Our Ref:239848
Department Ref: SSD-9827

**RE: PART LOT 4 DP 1238761
45 HONEYSUCKLE DRIVE, NEWCASTLE.**

Thank you for your letter dated 21 February 2020 providing the Departments request for additional information in relation to the above application following further assessment. Please accept this submission as our formal response to the matters raised.

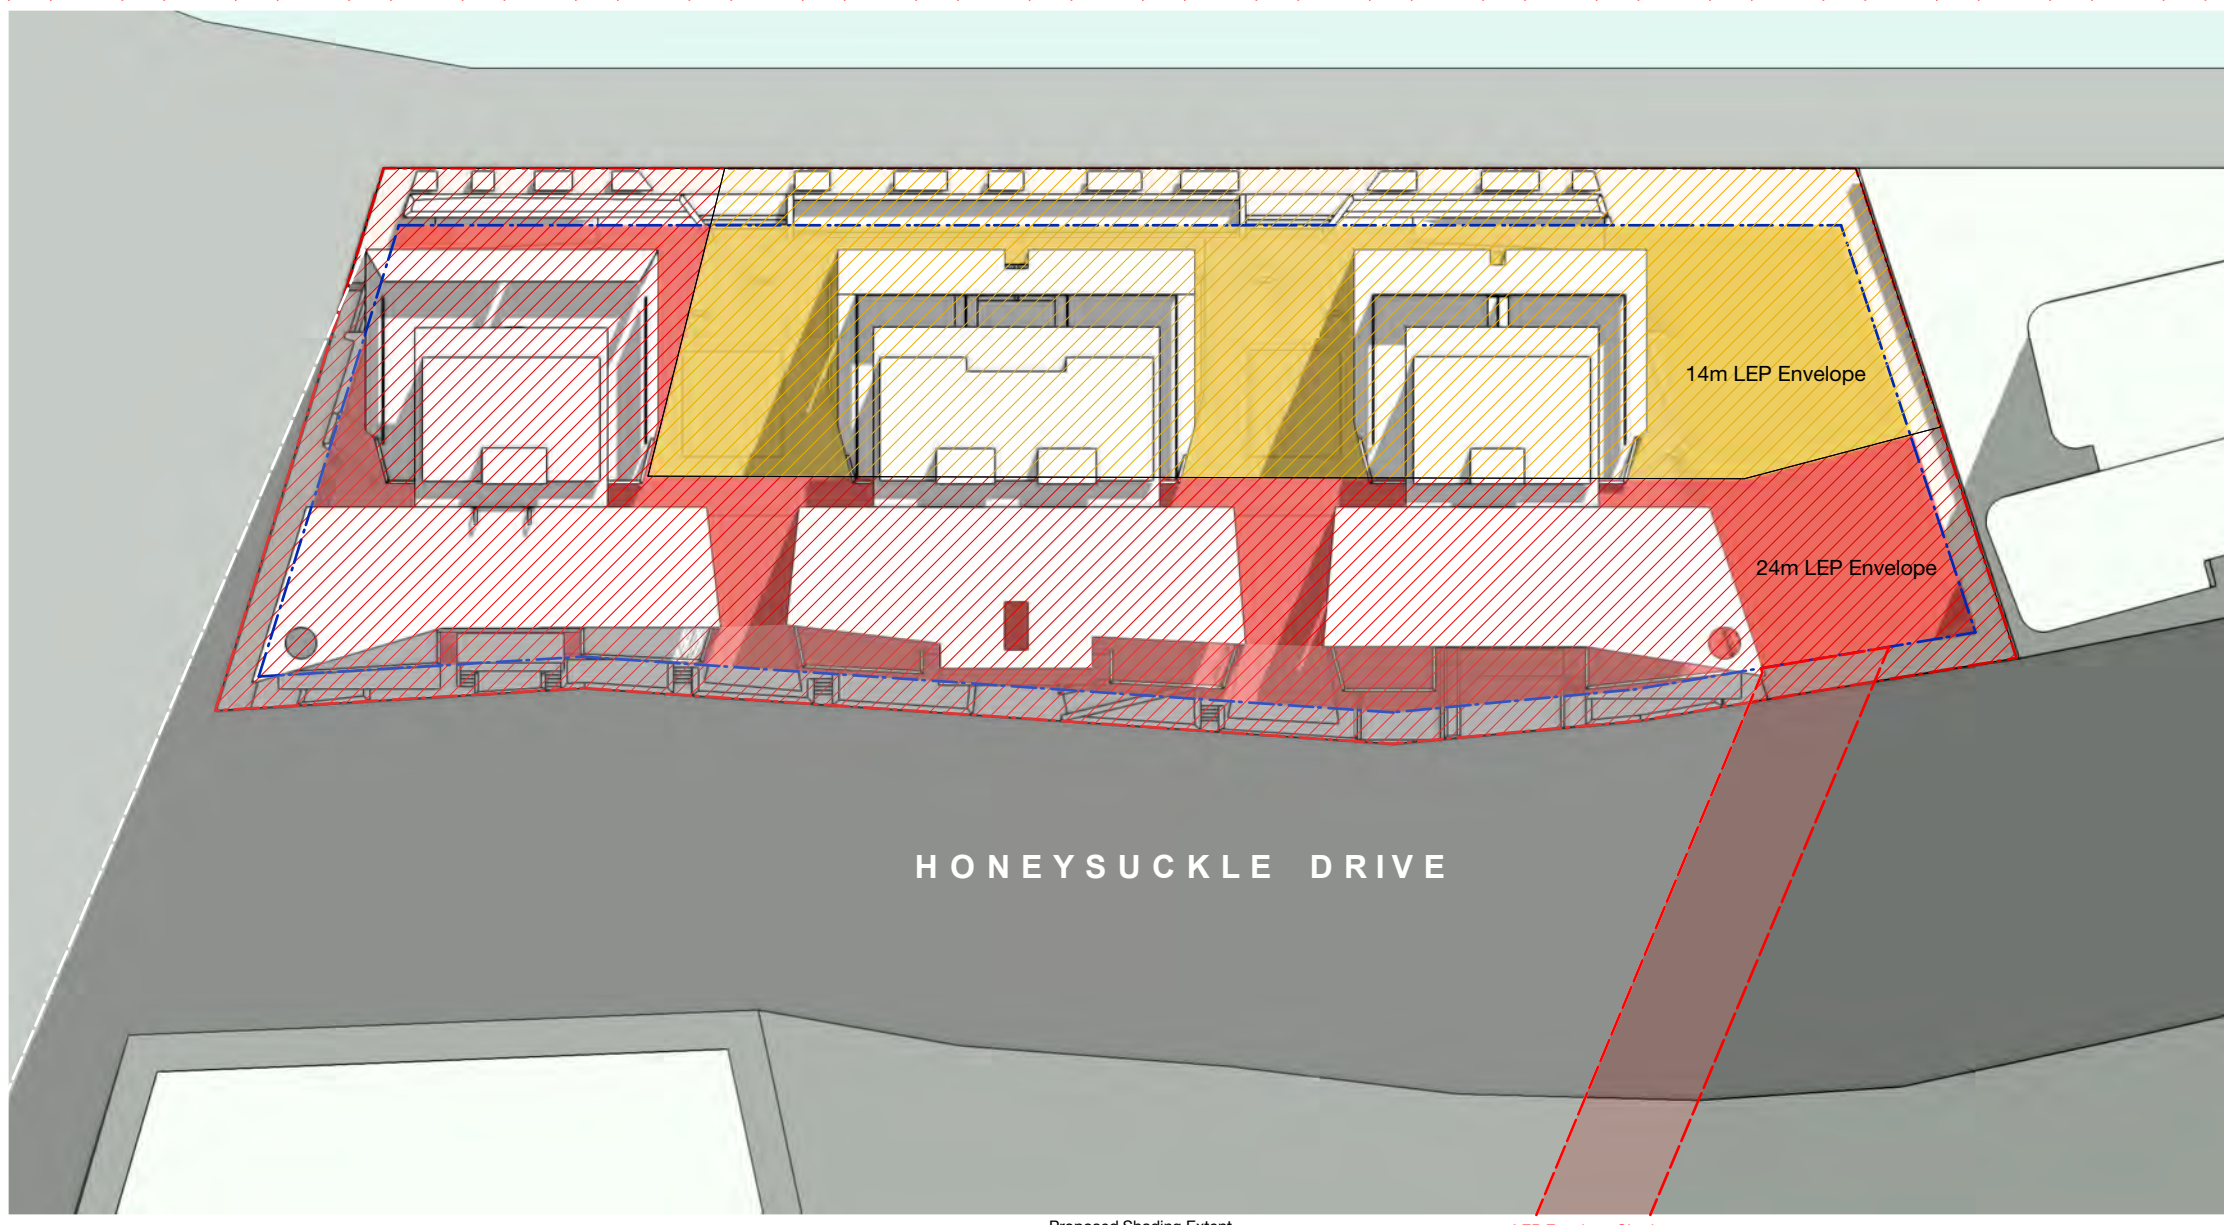
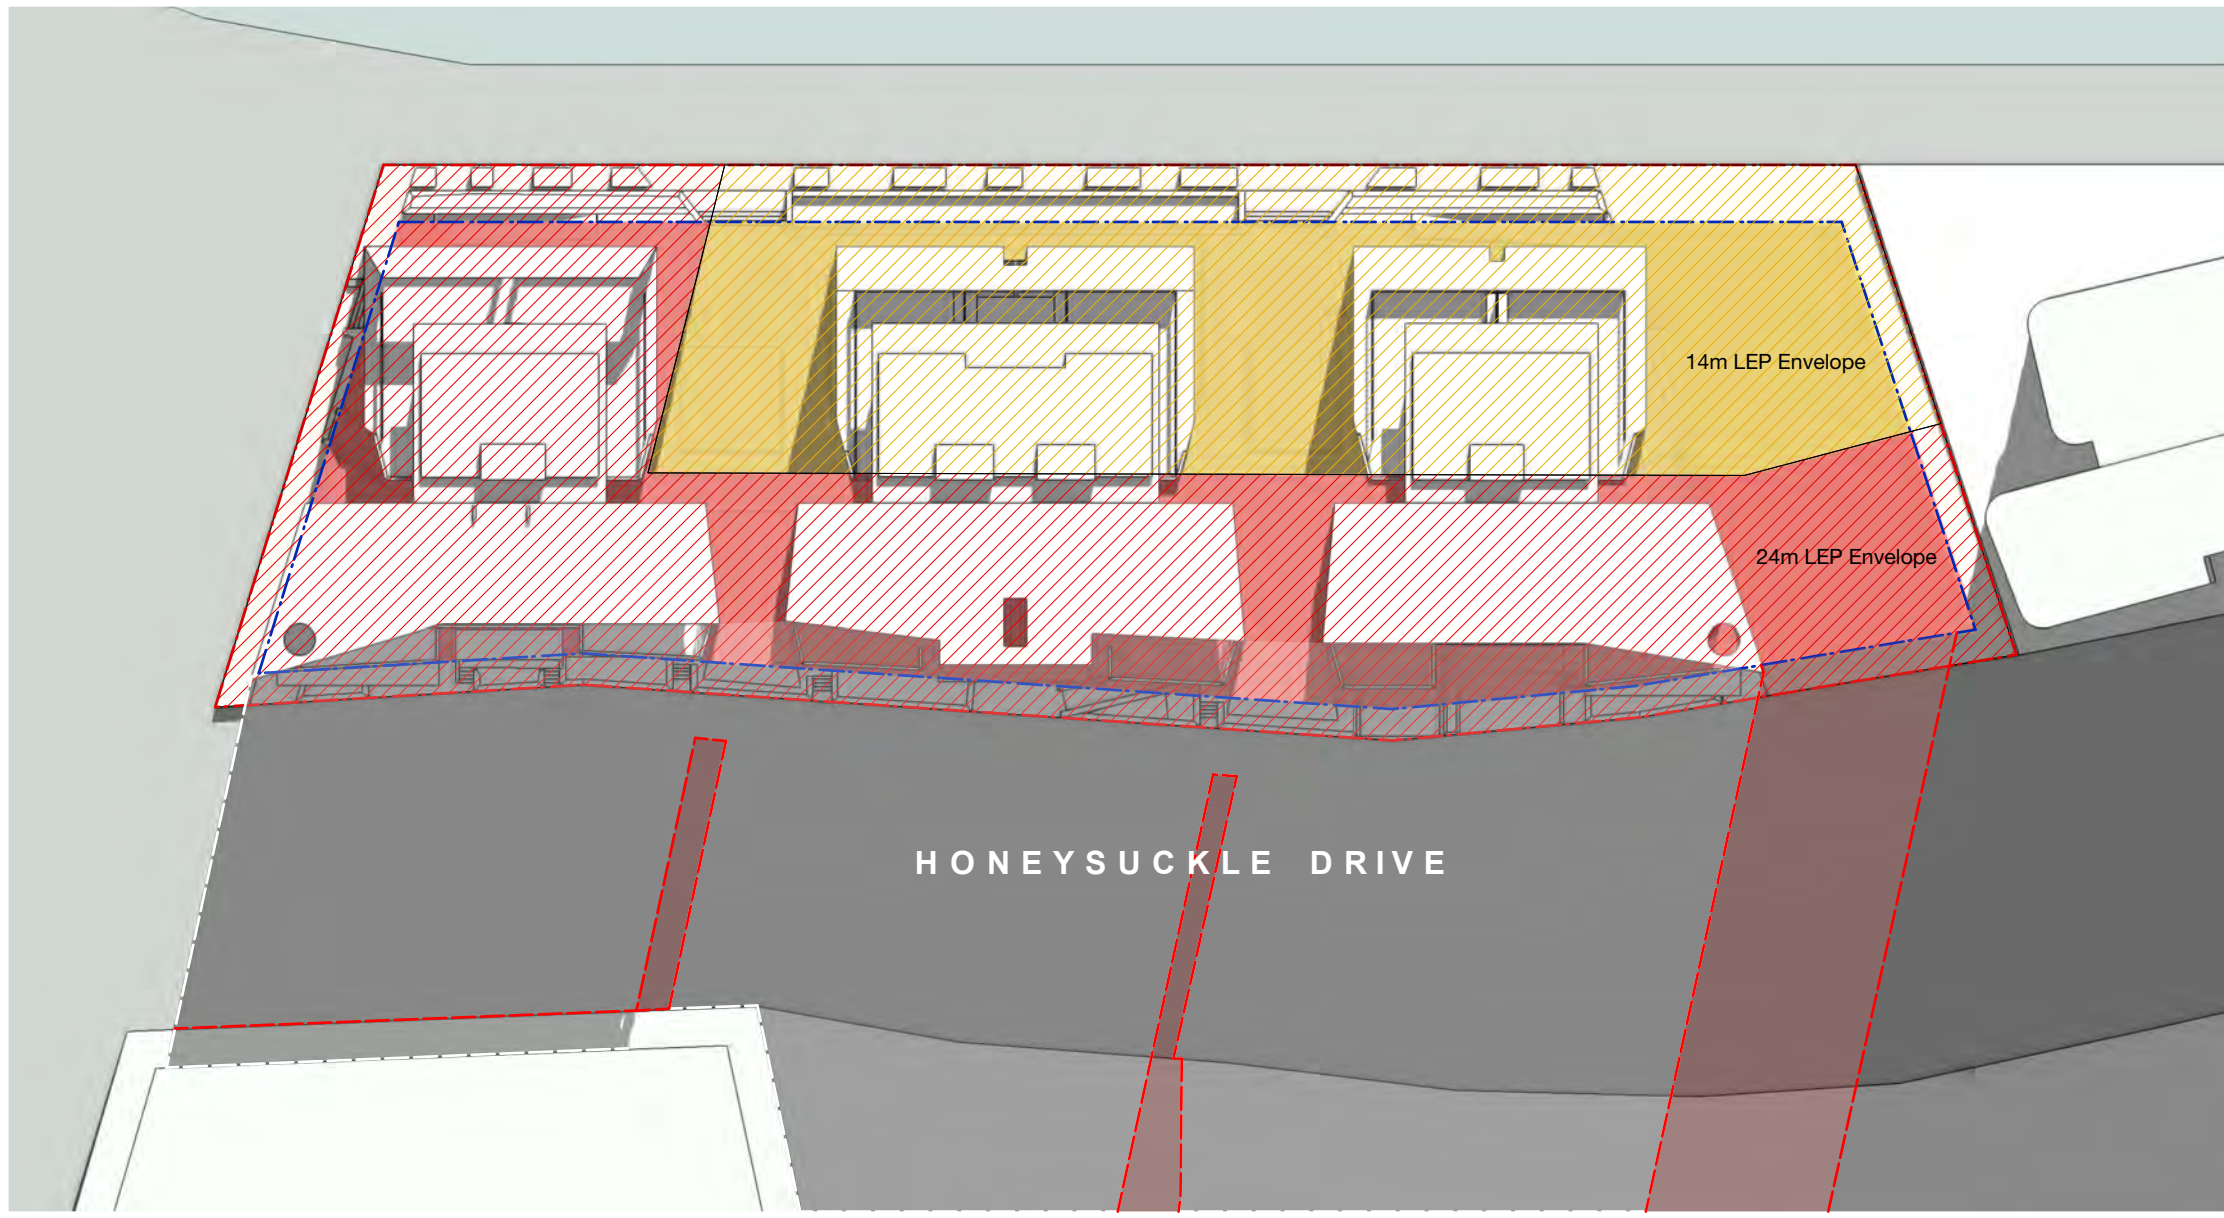
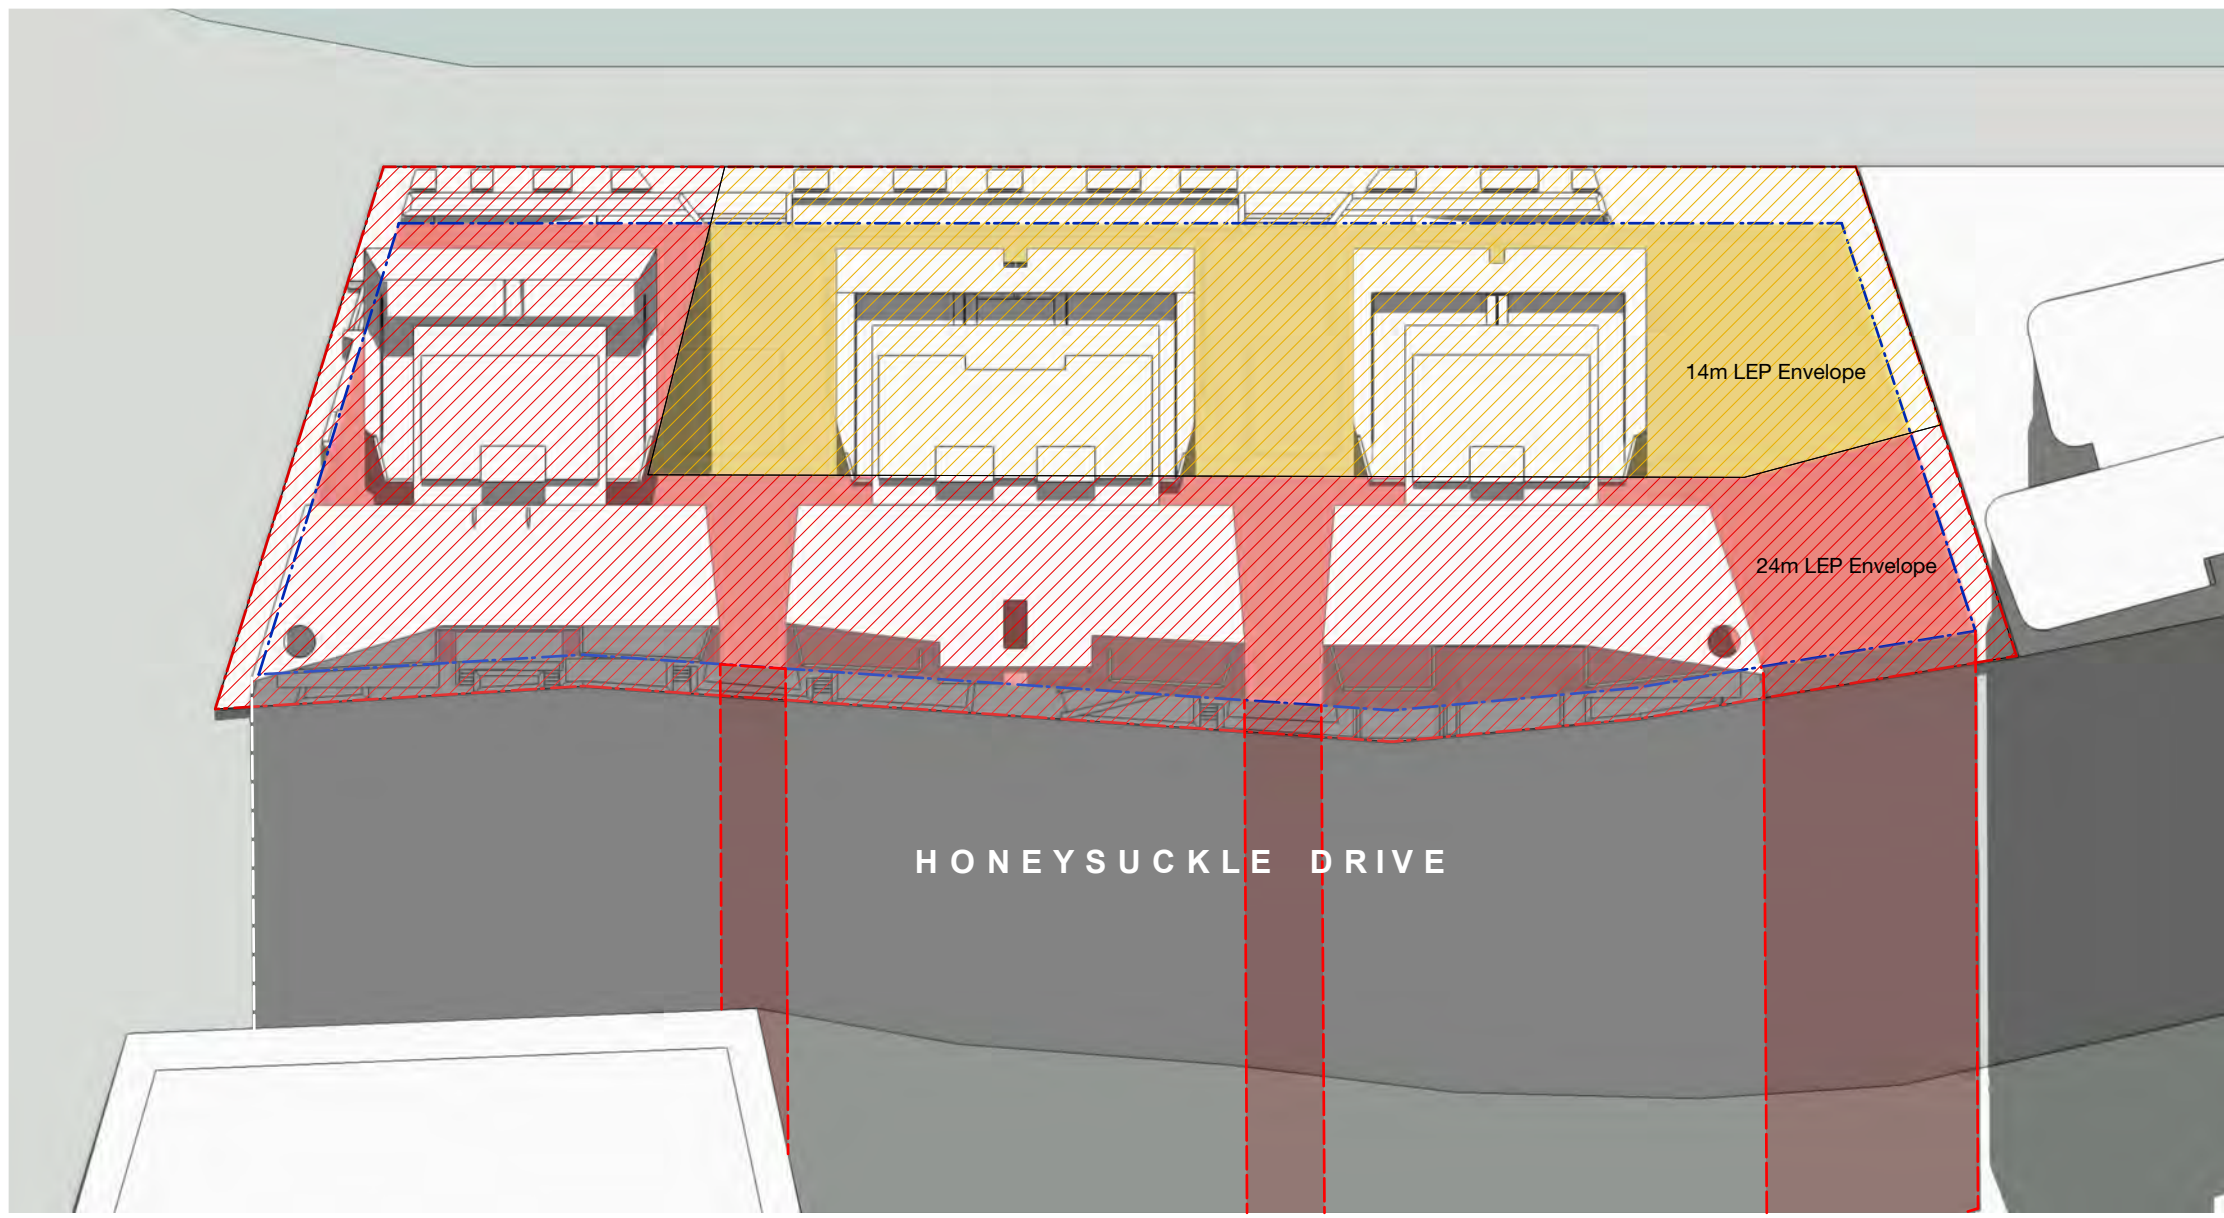
Provide an assessment of view loss impacts, using Tenacity Principles, to the residential apartments and hotel rooms of the approved development at 42 Honeysuckle Drive. The assessment should consider the current proposal as well as an LEP compliant scheme.

A typical built outcome on 45 Honeysuckle Drive would be one assumed to comply with the relevant planning provisions. In this regard, it is considered that a compliant development outcome would see the entire footprint of the site developed up the maximum height would have a greater impact on views from 42 Honeysuckle Drive than what is currently proposed.

However, because the proposed development footprint has been reduced and because a more slender built form with separation between the three (3) buildings the retained views from 42 Honeysuckle Drive are improved. Views from 42 Honeysuckle Drive will be available through the site and via the available space along the Cottage Creek corridor as shown on the below photomontage, which outlines a compliant scheme (in block form) and the proposed development.
